From: Sue Howell
Sent: 16 November 2017 16:28
To: Planning.Responses
Cc: David Innes
Subject: RE: Planning Consultation on: LU/282/17/RES

Comment from Greenspace

Comment regarding residential apartments and changing facilities building towards the open space and playing fields area to the North East of phase 2 of this application LU/282/17/RES following outline consent LU/355/10.

TITLE
COURTWICK, LITTLEHAMPTON
Block Plan

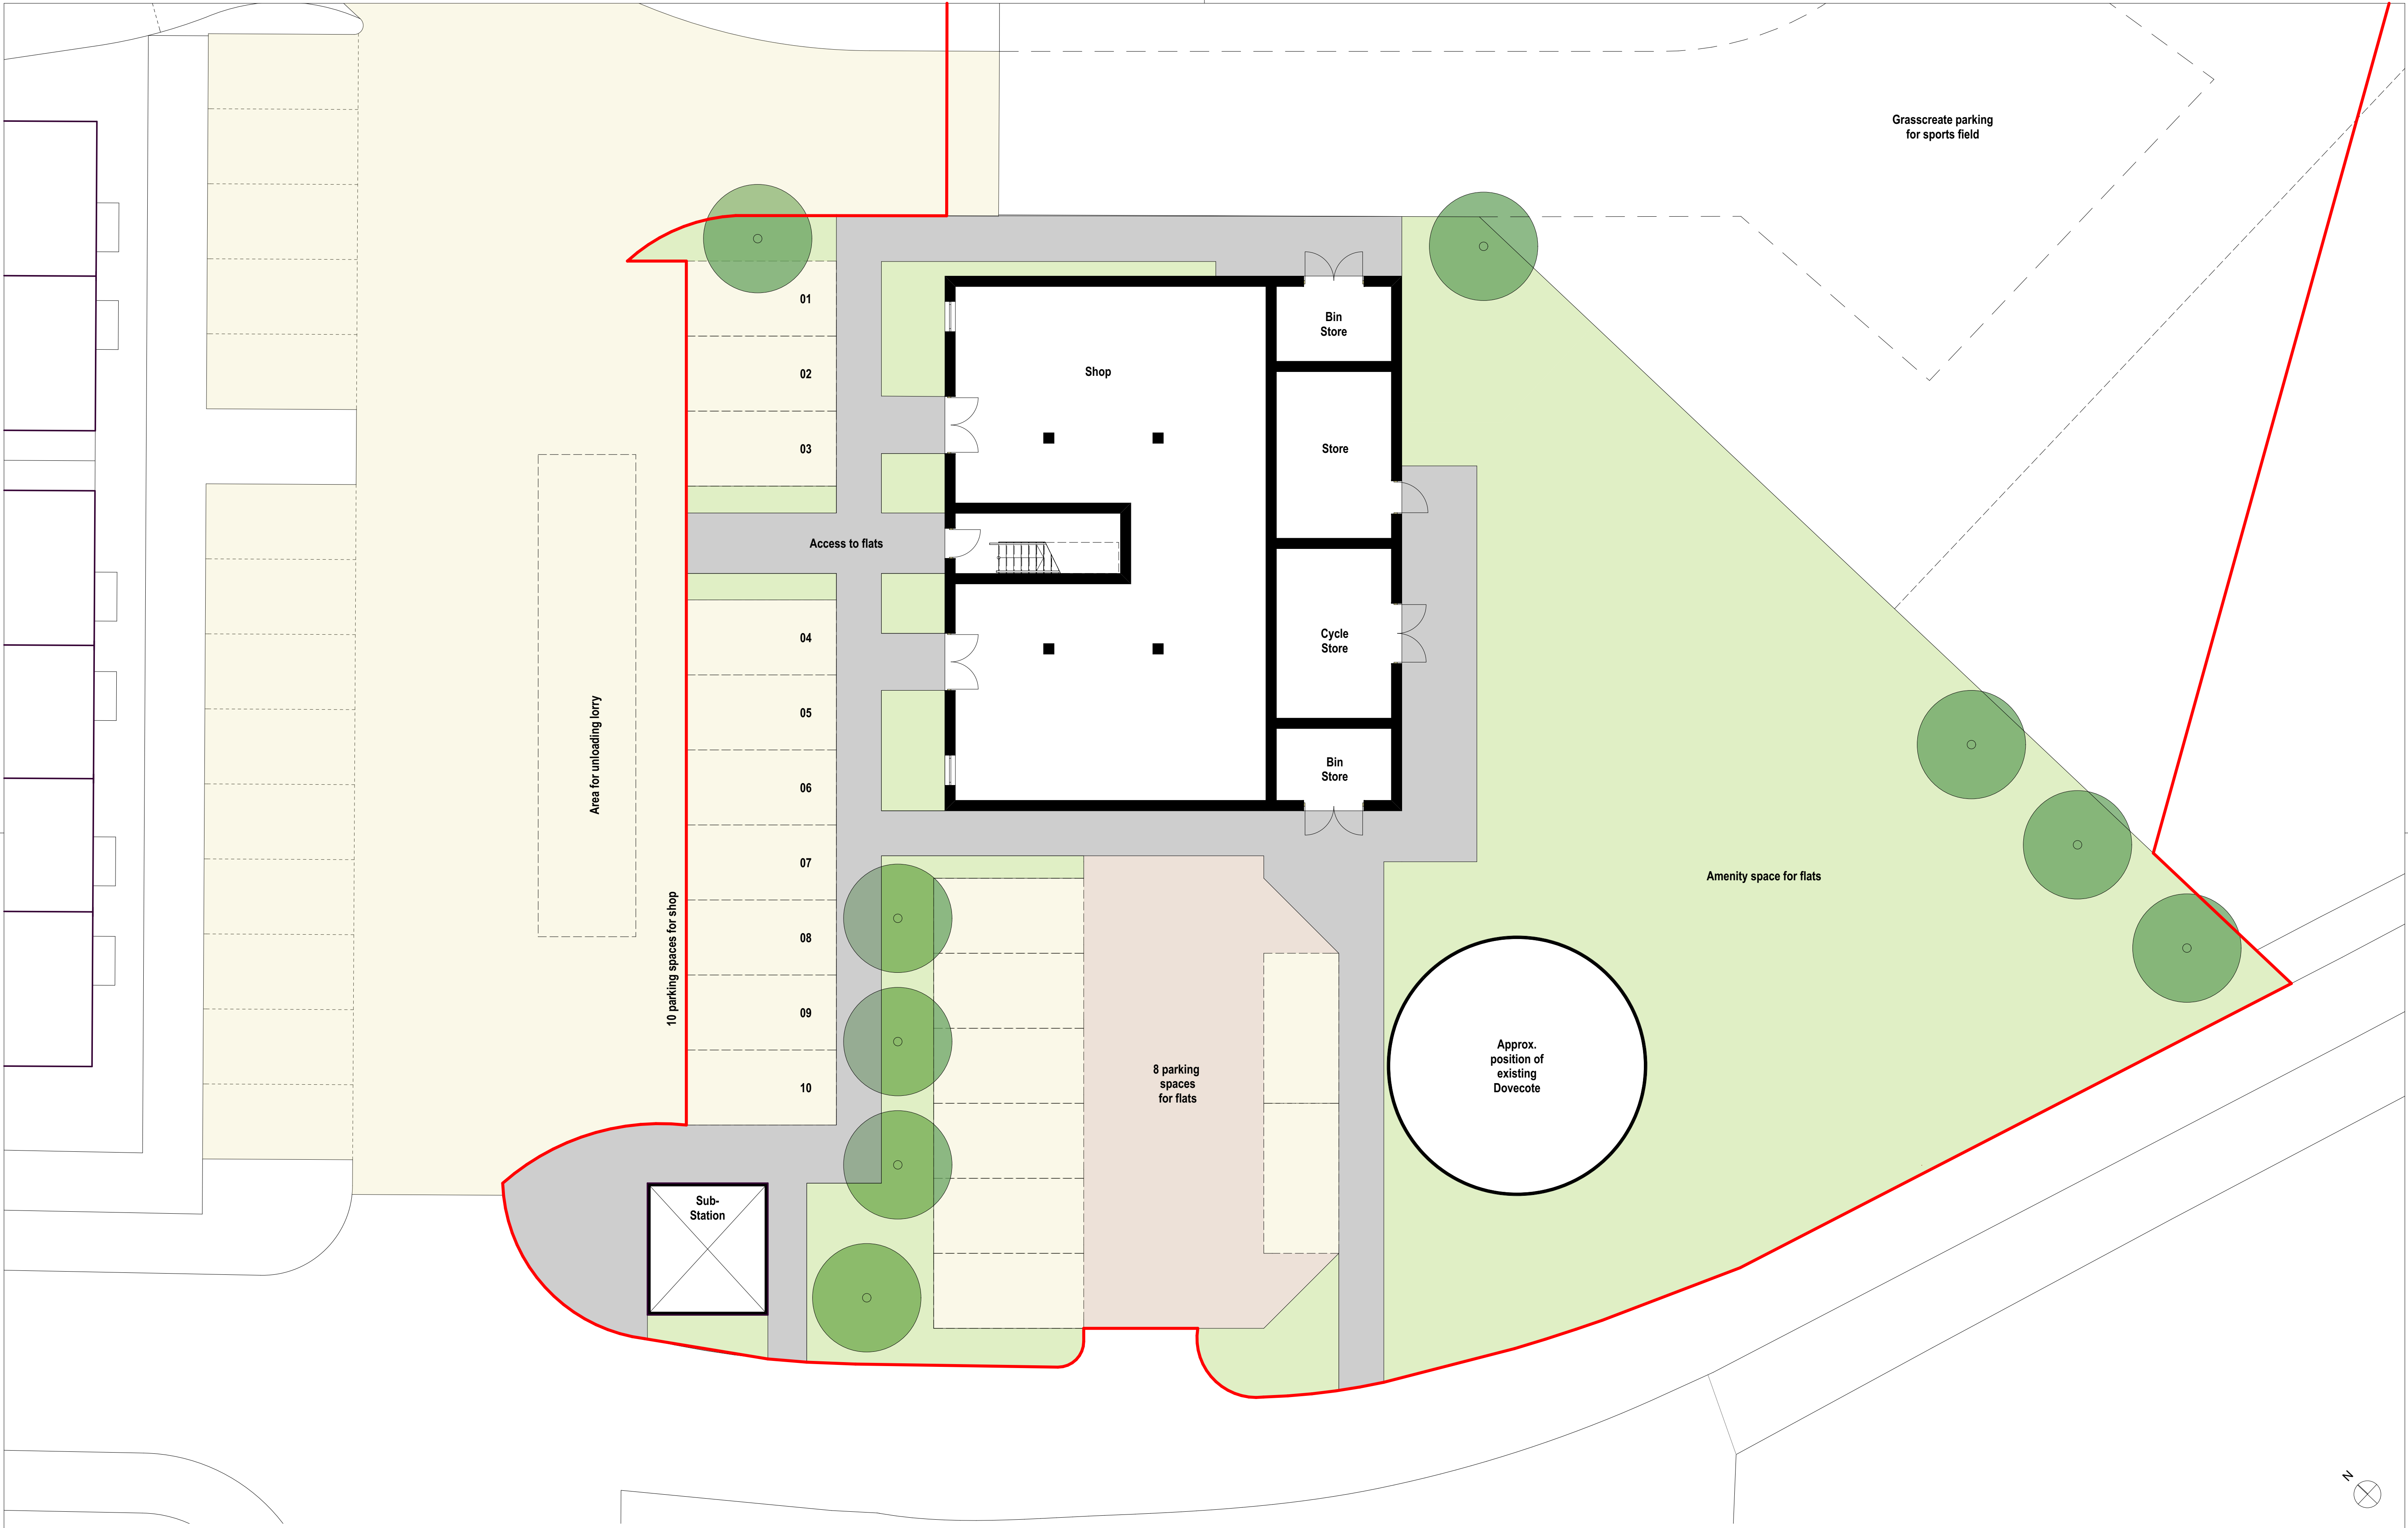
The detail would appear to show a change from the detail supplied at masterplan stage in relation to an element of the POS now to be developed. Whilst the siting of the changing facility is now closer in relation to the proposed sports offer we would require detail in plan form of the landscaping being proposed, showing plant species, density and size at time of planting.

We would require this also for the commercial /residential unit along with confirmation of the parking facilities ie number of spaces and layout, being proposed for both of these.

In addition please seek clarification re the position of the NEAP indicated in the outline application masterplan and now appearing to be in conflict with the proposals indicated under LU/282/17/RES. Please request detail for clarification of the offer being proposed under NEAP.
